ASSESSMENT REPORT

Section 75W Modification Huntlee New Town Stage 1 (MP10_0137 MOD 3)

HUNTLEE MASTERPLAN PRECINCT 2 STAGE 2-5

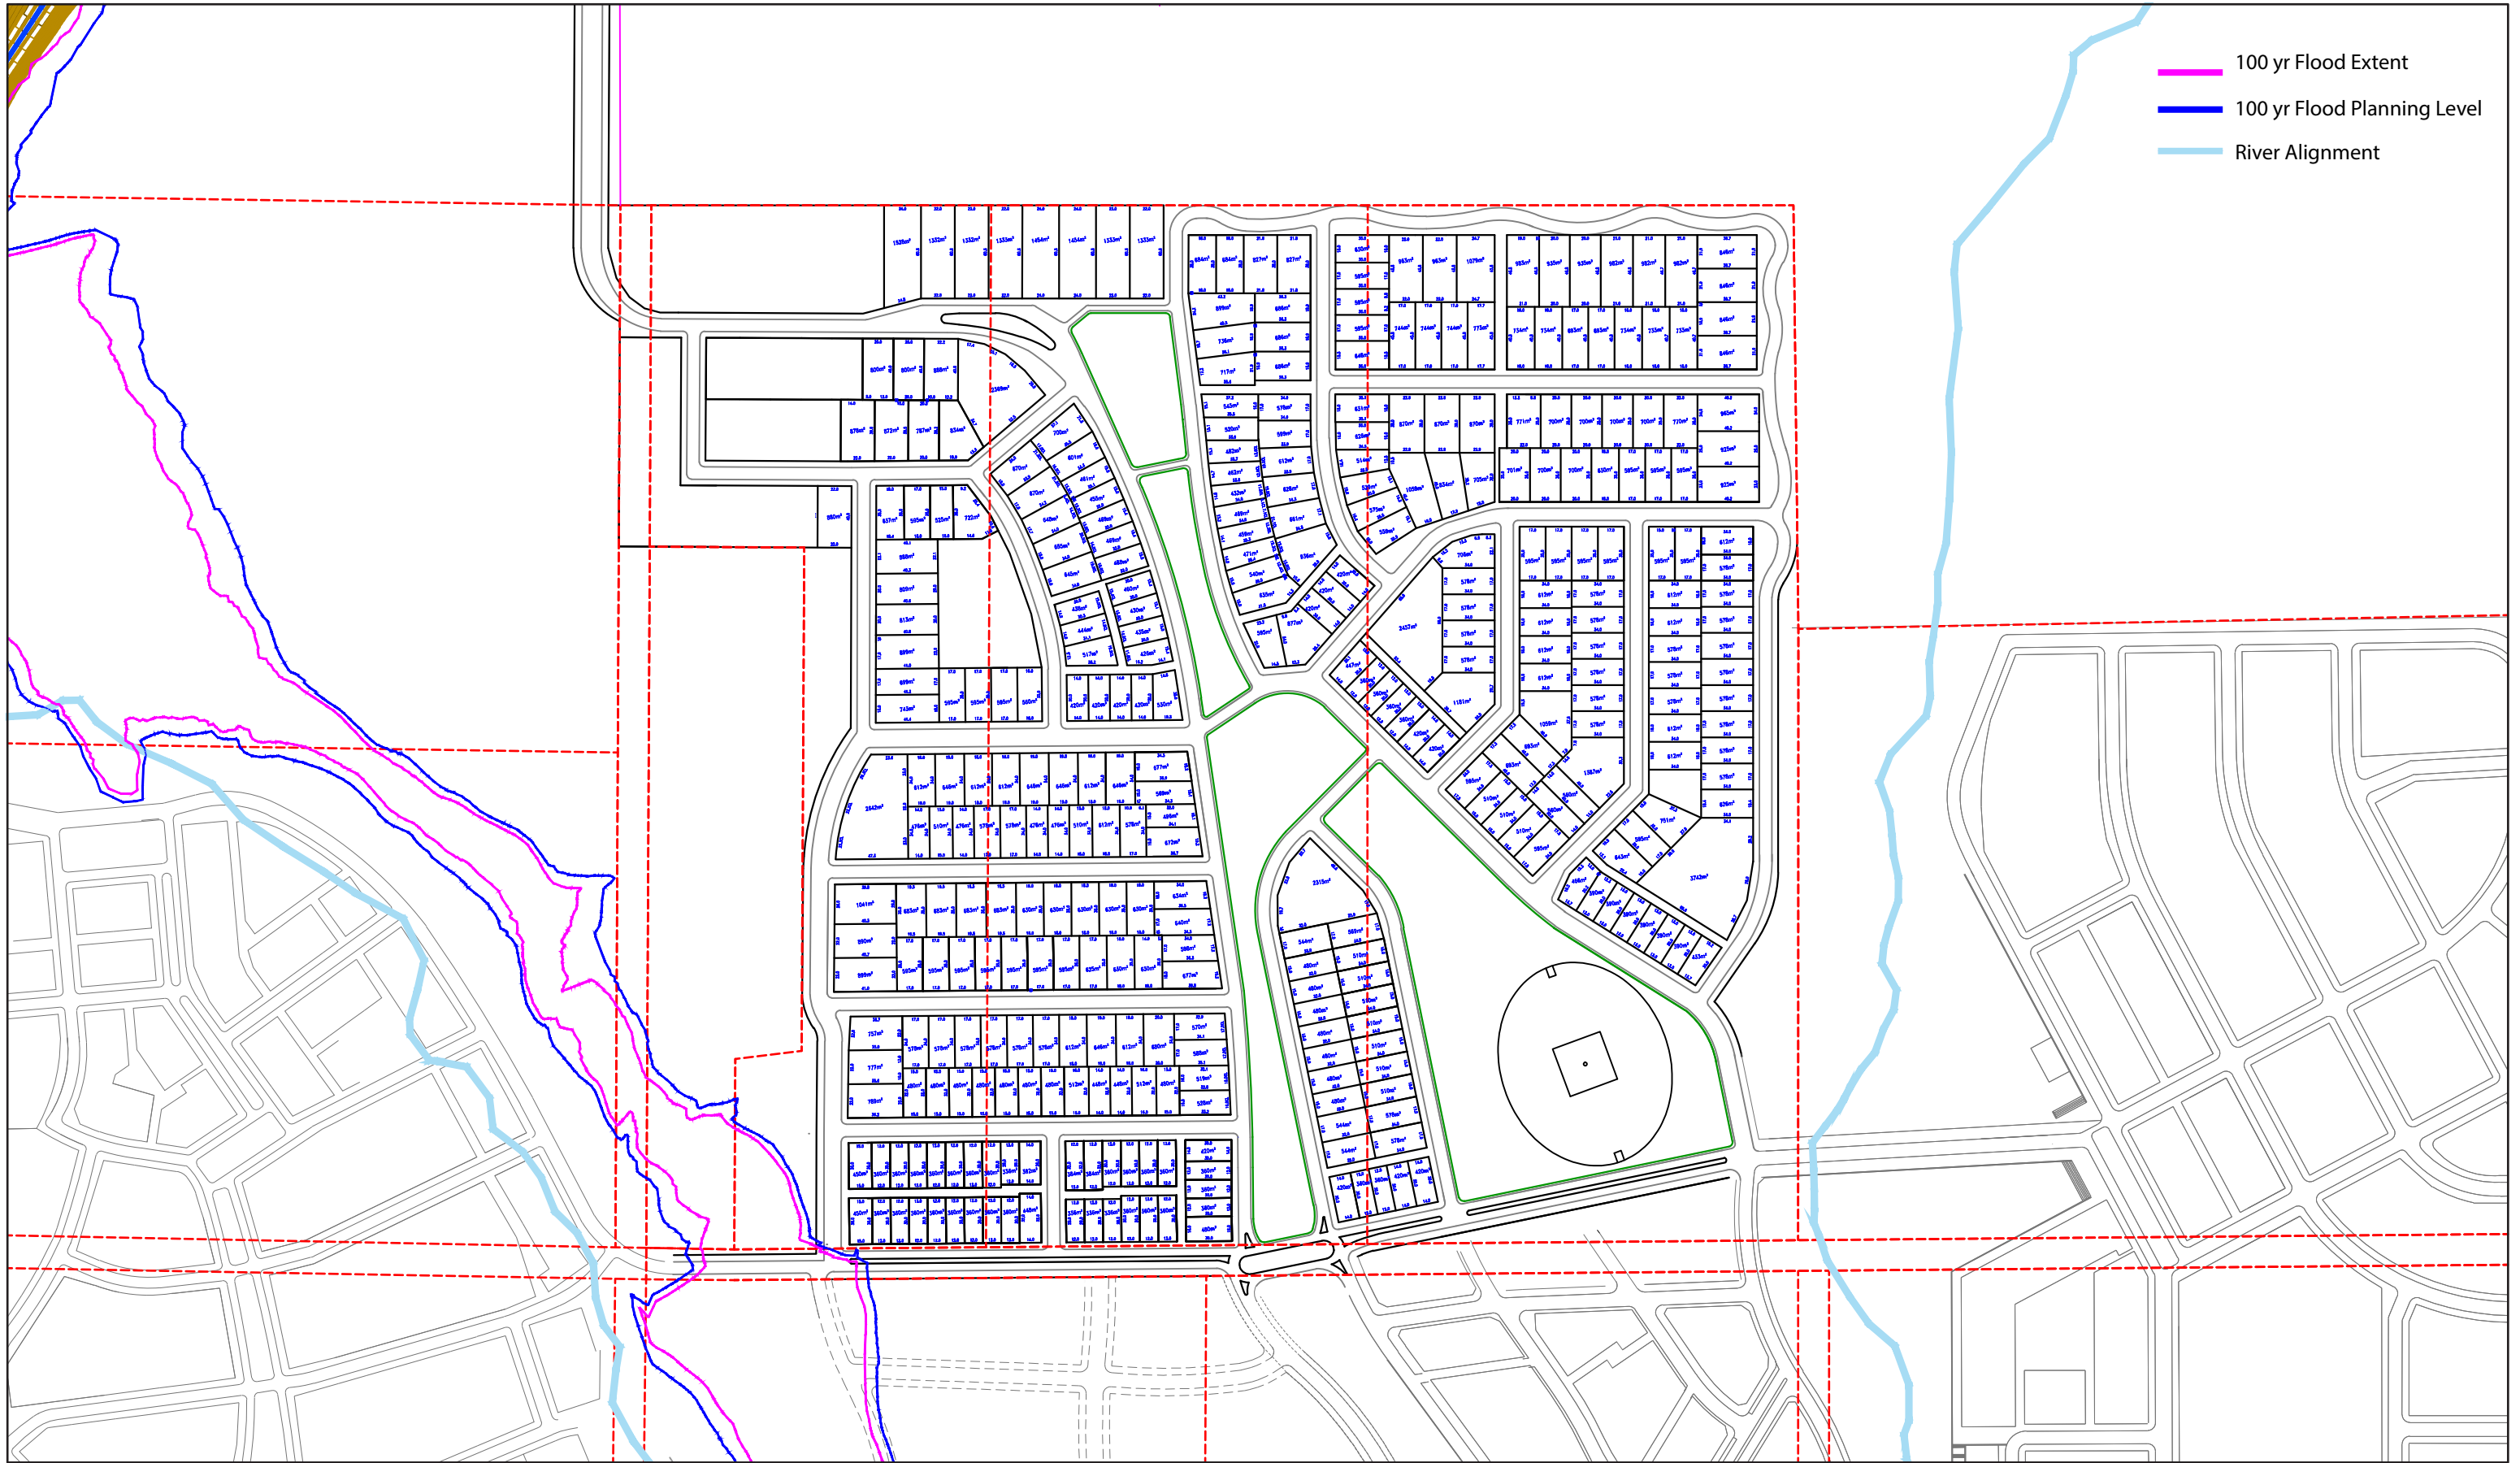
Council did, however, raise concern regarding the management of stormwater for lots along the western boundary of sub-stages 2 to 3 located near two first order streams. Council advised that the Proponent would need to demonstrate that the proposed subdivision layout could be engineered to mitigate stormwater flows so no burden is placed on Council or future landowners.

Council raised concern regarding the potential stormwater impacts on lots within sub-stages 2 and 3 located nearby two first order streams (**Figure 10**). Council advised that the Proponent would need to demonstrate that the proposed subdivision layout could be engineered to mitigate stormwater flows so no burden is placed on Council or future landowners.

To address Council concerns, the Proponent advised that the subdivision is to incorporate stormwater management infrastructure including:

- road grading to convey overland stormwater flows to the west and then to the south to the approved bio-retention and stormwater management systems;
- formalised curb and guttering altering the overland flow path; and
- inter-allotment drainage lots without gravity drainage to the street to limit stormwater flows across properties.

Council has confirmed that this combination of infrastructure for stormwater management is likely to be sufficient to reduce the impact of the proposed subdivision layout. However, Council requested that detailed engineer's drawings of the overall stormwater management scheme be provided in order to confirm that the proposal would not impede the future

However, as the stormwater management scheme for lots associated with the two streams may have implications for Council's long-term management of stormwater in the area, it is considered reasonable that the stormwater management scheme for this part of the site, be designed to the satisfaction of the Council prior to the issue of a Construction Certificate. An additional condition to this effect is therefore recommended to be included in the Notice of Modification accordingly.

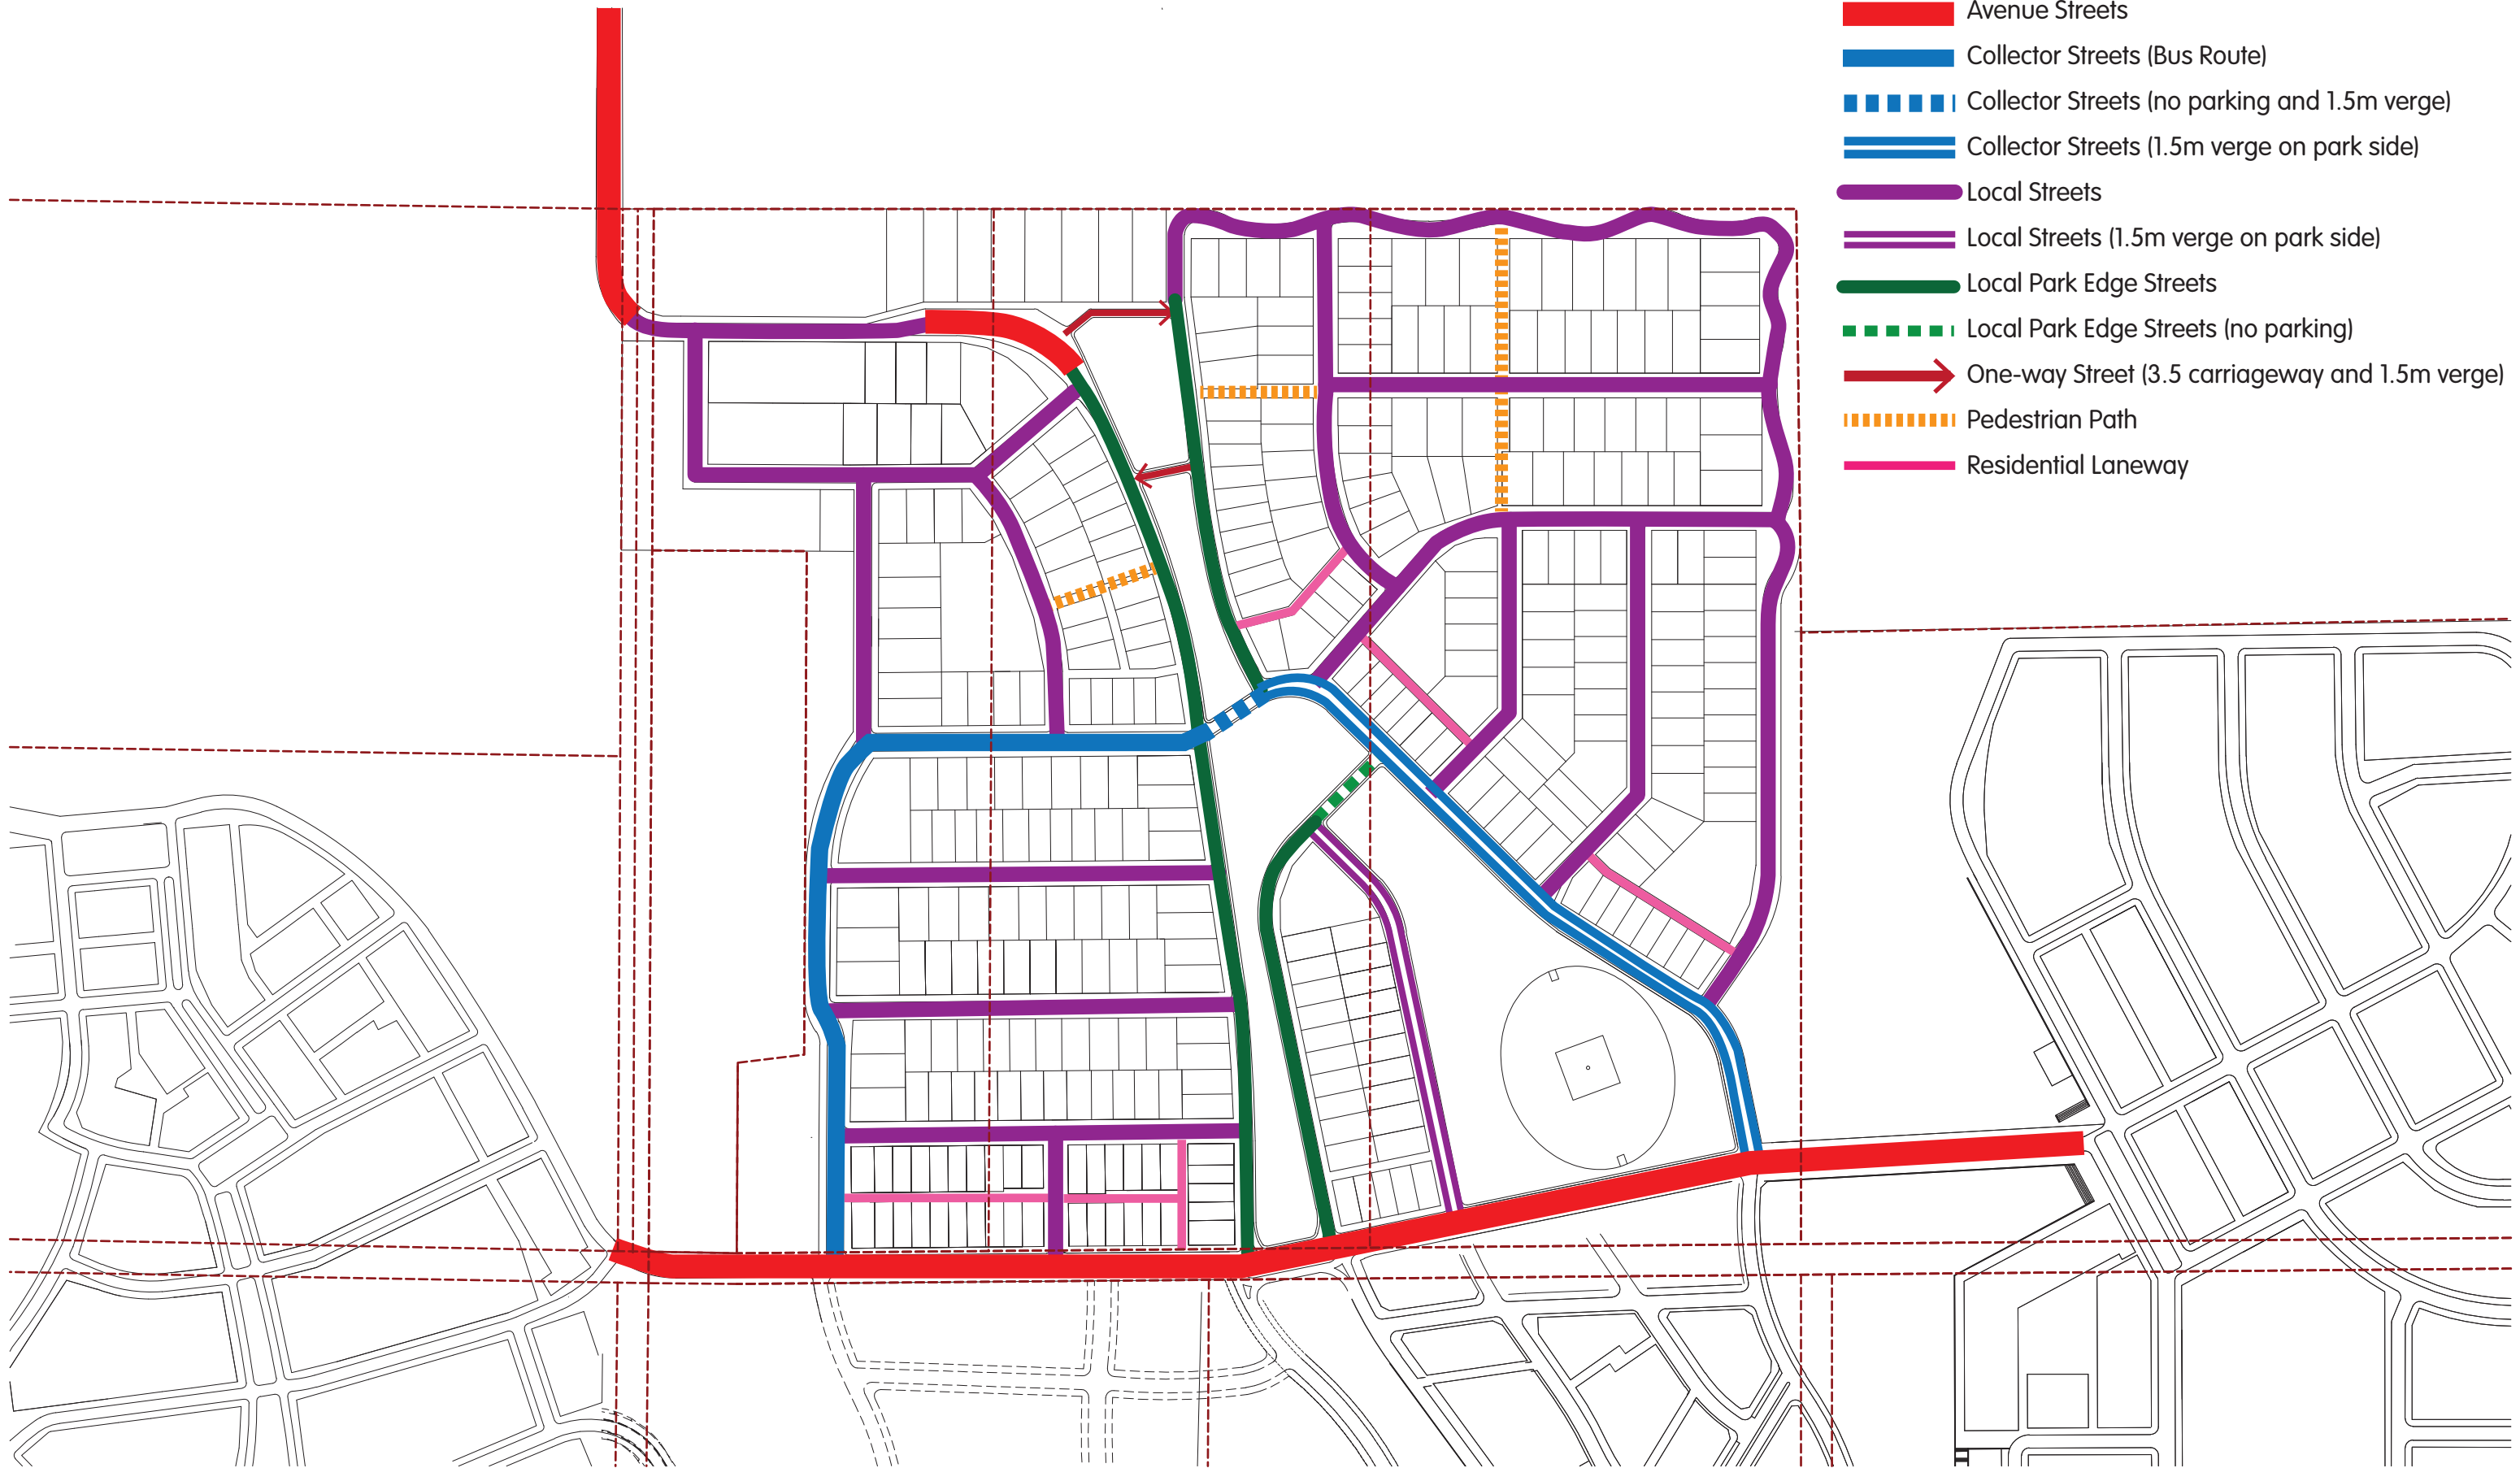
Council raised no objection to the request. Council noted its support for the relocated sports ground, revised lot layout in sub-stage 1a and the proposed additional plans and documentation. Council also noted its conditional support of the re-alignment of Central Avenue on the basis that vehicular laneway access is maintained for all lots adjacent to the Central Avenue.

Council raised no concern with the revised subdivision layout subject to laneway access being maintained for the small lots adjacent to Central Avenue. As demonstrated in **Figure 9** above, the small residential lots adjacent to Central Avenue retain laneway vehicle access.
